From: Guy Rochez [REDACTED]
Sent: 24 March 2021 14:37
To: Nicola Moore
Cc: Planning.Responses; andrew bridges
Subject: Re: Request for further information FG/46/21/PL
Attachments: 028_Plans Existing Proposed.pdf; FG_46_21_PL202103241155136546.pdf

Drawing Title
028_03 Proposed First Floor
Plan
Land between 11A The Grove
and 30 Brook Lane, Ferring

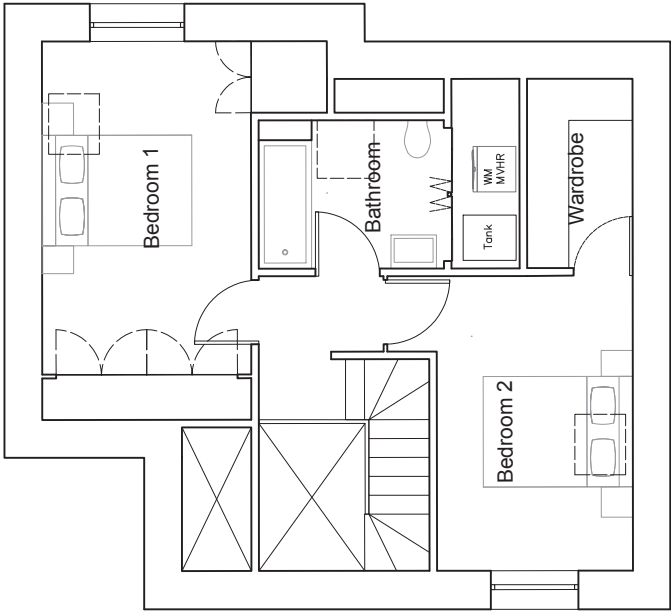
Further to the email below stating that only 2 out of 3 roof lights are identified on the first floor plan, I have checked the set of drawings I issued to you this morning and re-attach to this email, and there are 3 roof lights shown on the first floor plan. For clarity I provide the screenshot below with a red circle around each.
